CITY OF ALBUQUERQUE

July 16, 2014

RE: **2117 ST Cyr St**
Grading and Drainage Plan
Engineers Stamp Date 5/28/14 (K15-D097)

Based upon the information provided in your submittal received 7/7/2014, the above referenced Grading and Drainage Plan cannot be approved for Grading Permit or Building permit until the following comments are addressed.

**2117 ST CYR GRADING &
DRAINAGE PLAN**

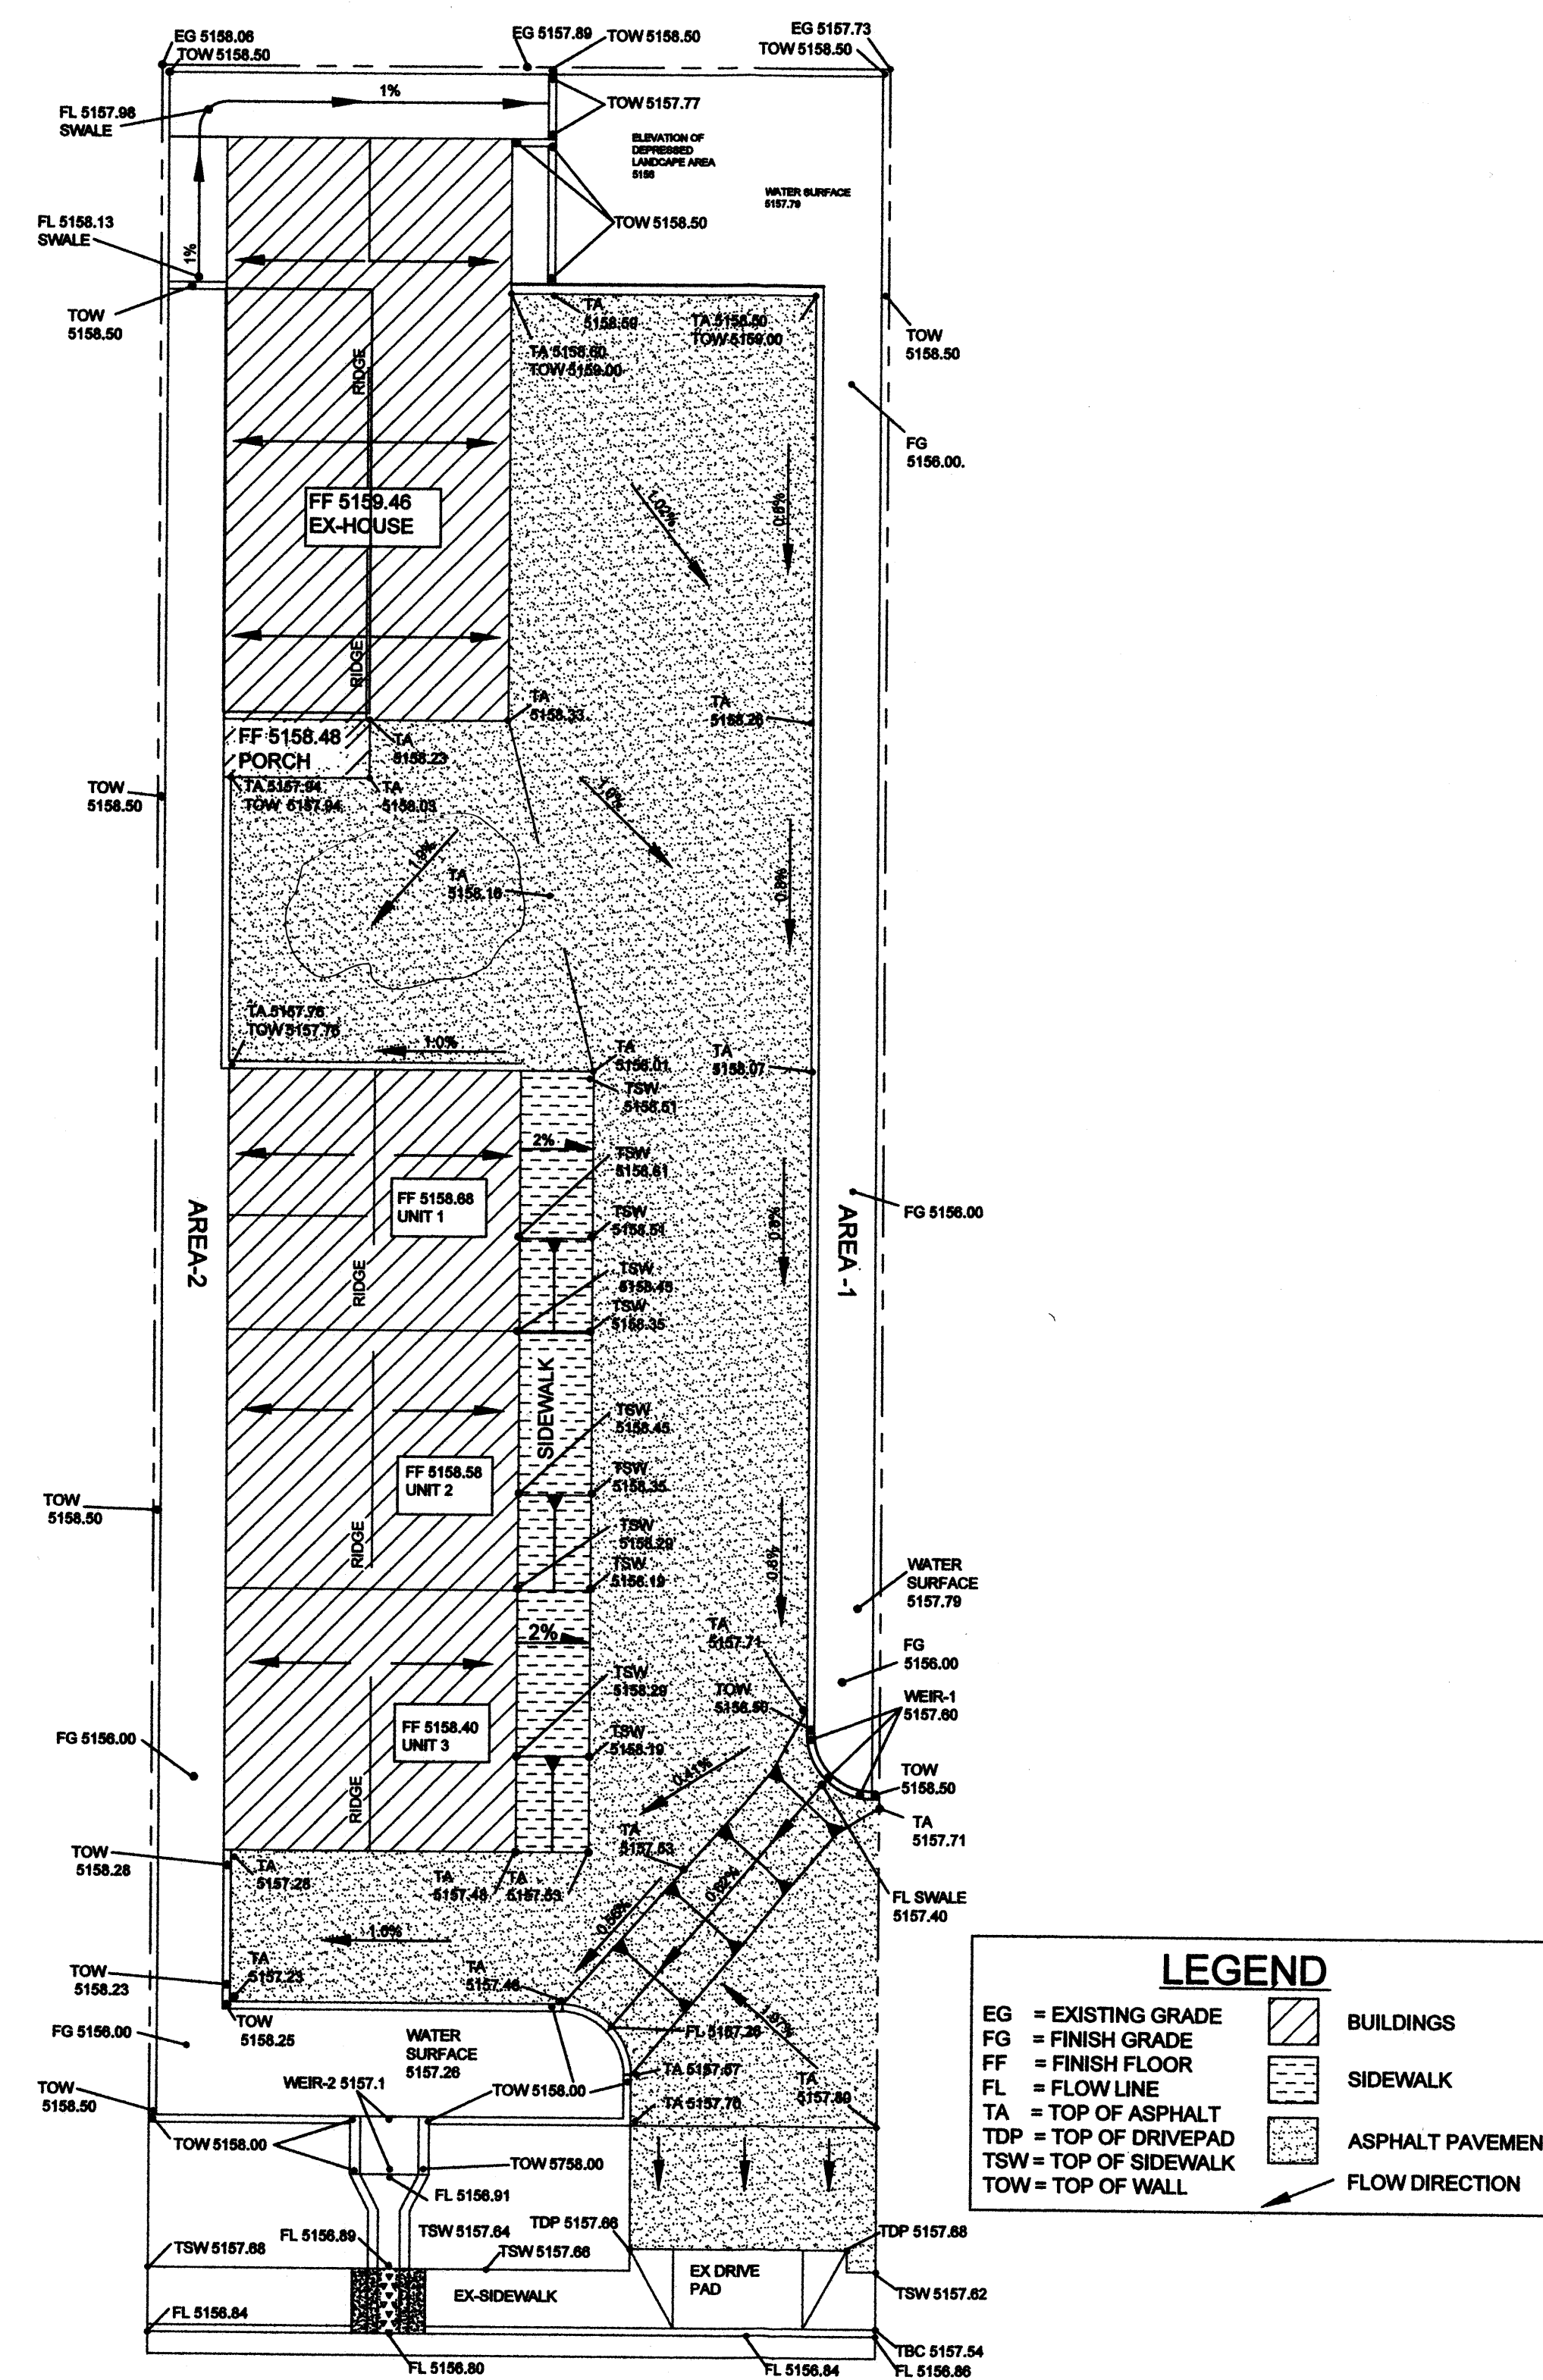
- An SO-19 is required for the placement of the sidewalk culvert. Therefore, the notes for an SO-19 should be placed on the plans. Also provide the hydrology department with two copies of the G&D plan.
